Planning Application Ref: BN/51 & 52/16/RES 10th Nov 2016 [[now BN/32/17/DOC – latest comments in blue typeface](#)]

Location: Land at former Pollards Nursery, Lake Lane, Barnham

Description of works: prev. Reserved Matters Application [now Discharge of Conditions](#)

Title: **External Levels & Features Layout Sheet 2 of 3**

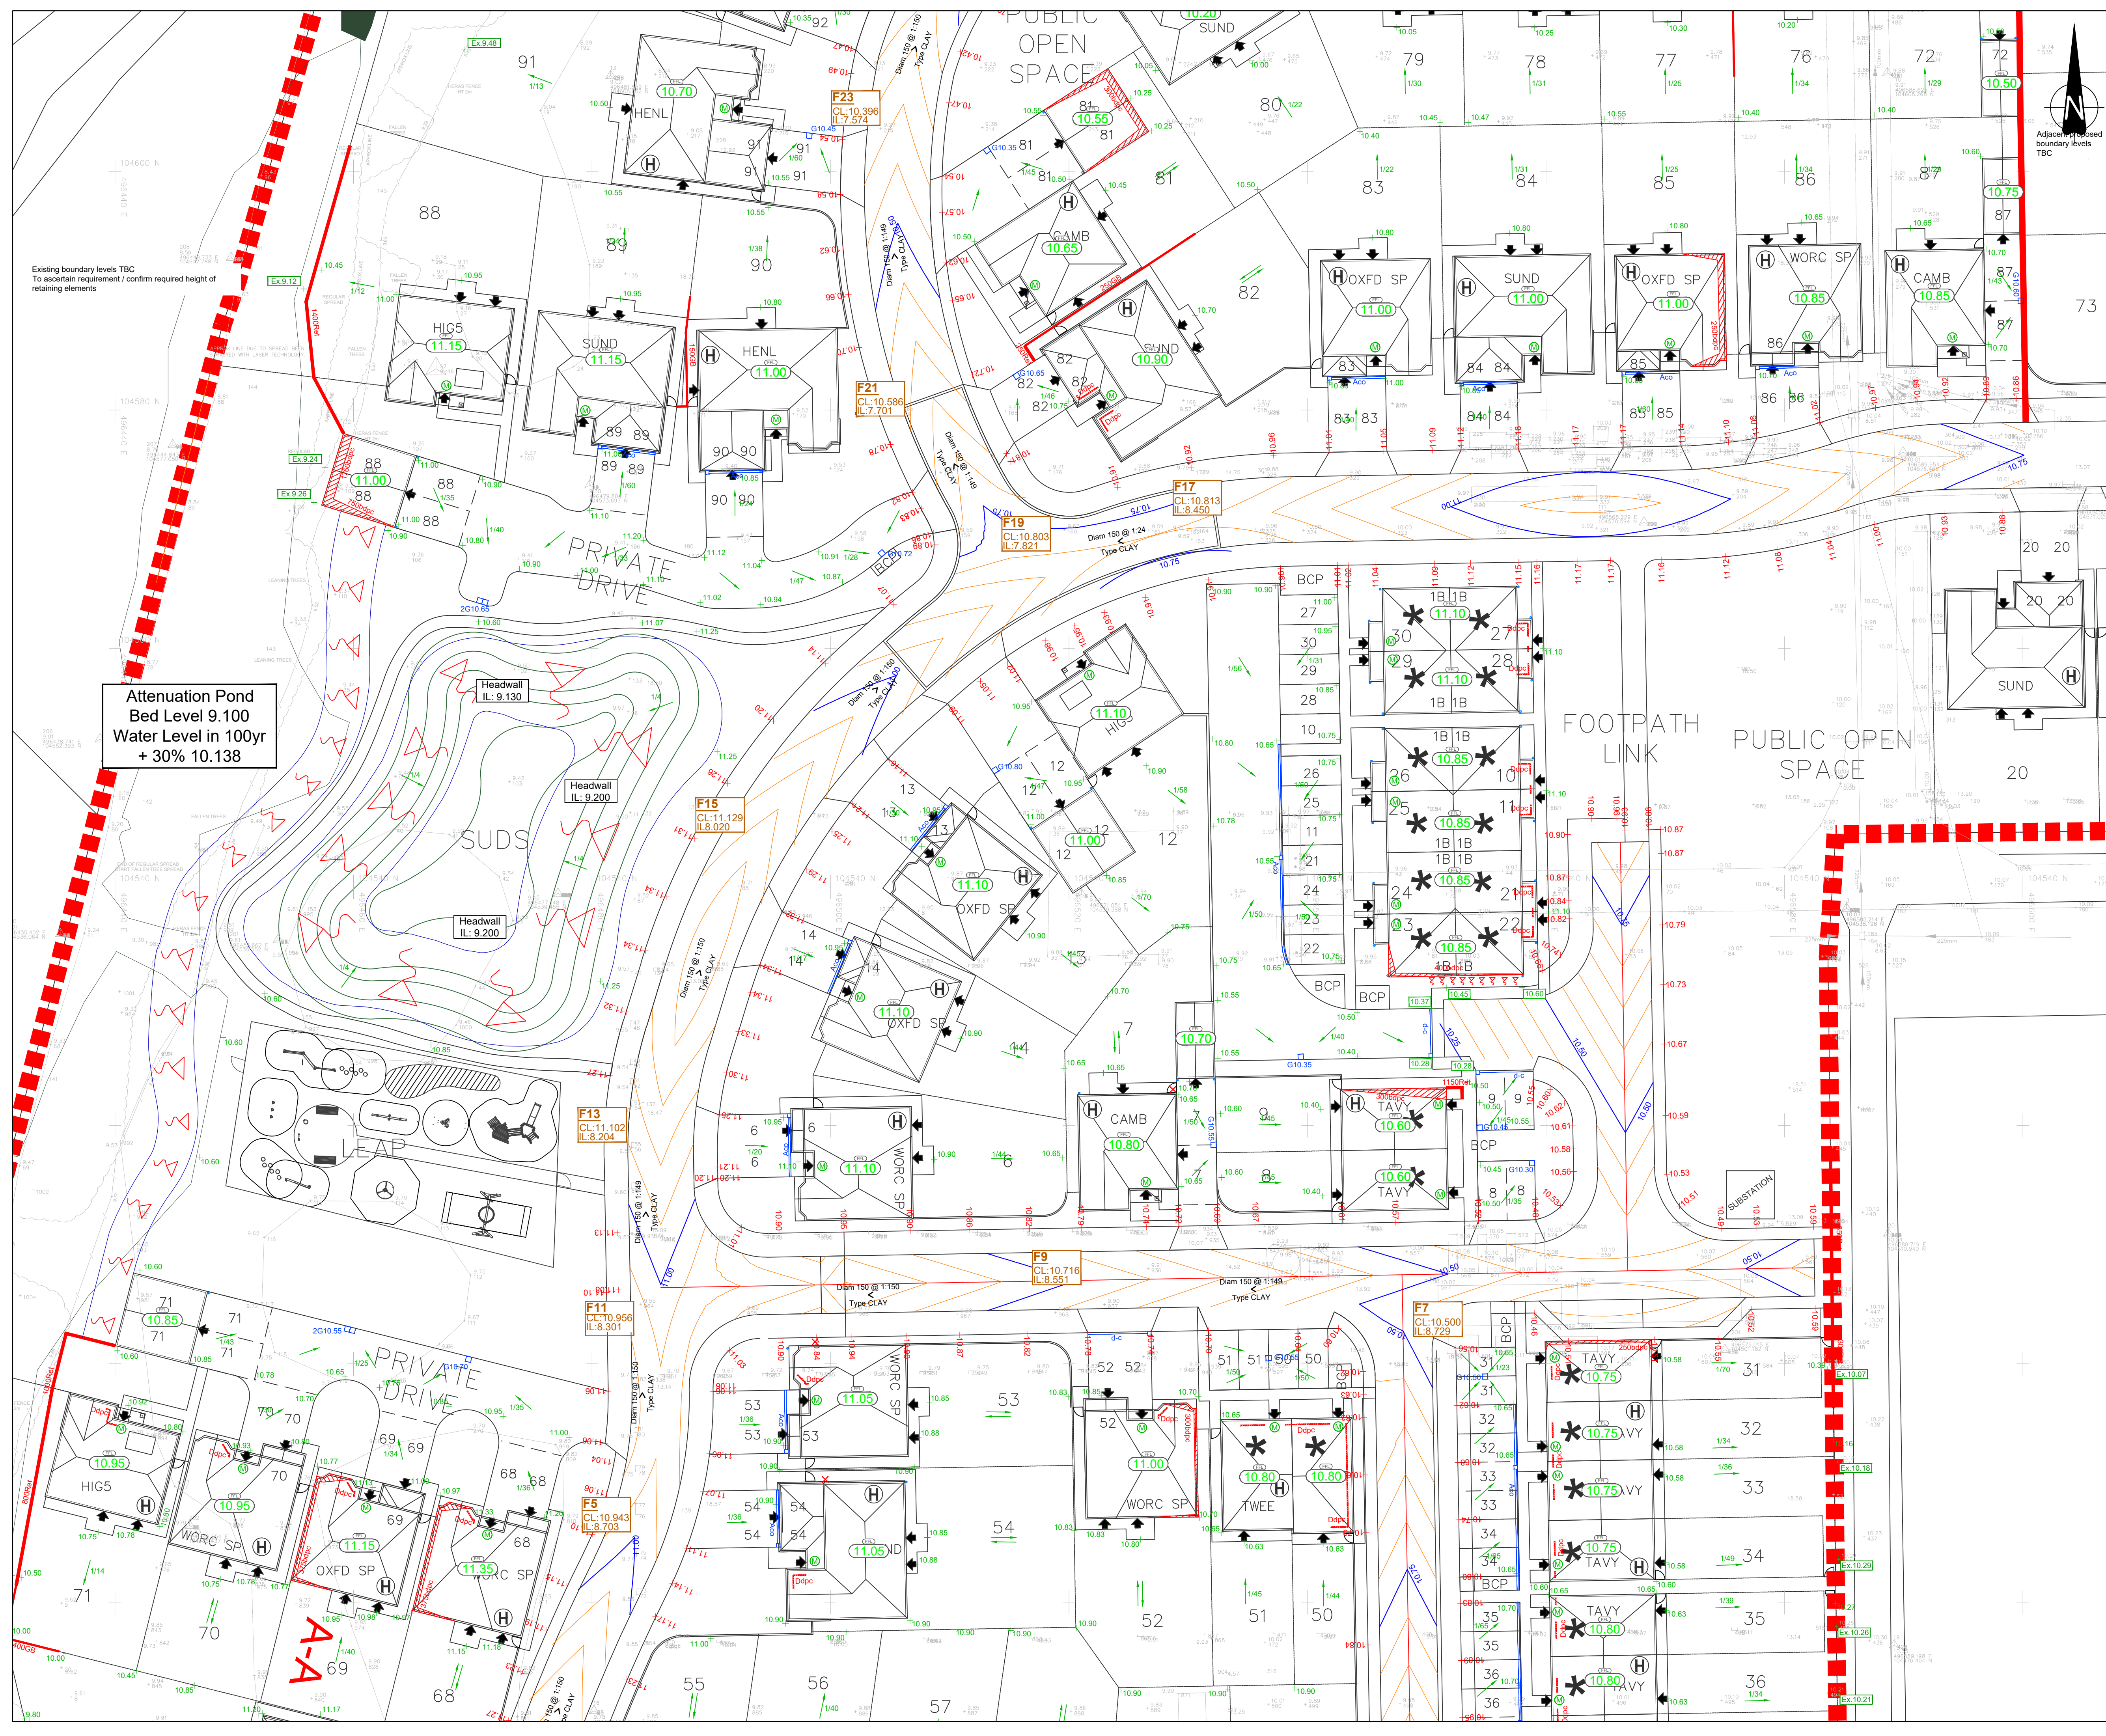
- There is evidence of rootplate failure in some of the Leyland Cypress and these failures will continue and this feature has a short life expectancy.
- A Balancing Pond has been dug in the top corner of the site close to the road and a large pipe cut through the tree belt alongside the road so that it can discharge into the ditch.

- I have concerns that in undertaking the work to form the balancing pond roots have been severed and some tree destabilised in terms of root hold and at risk of failure close to a main road.
- The Leyland Cypress are at risk of rootplate failure.
- [As far as I am aware \(I was not acting tree officer at that time\) the requirements of Condition 11 have been met and all tree protection was in place prior to any start being made on site!](#)

- Remove the trees around the balancing pond pipe that have been destabilised.
- Remove the already fallen trees in the Leyland Cypress shelterbelt and also top out the entire run by 4m to 5m to stabilise.
- [The above recommendations remain valid but I can see no reason not to discharge Condition 11.](#)
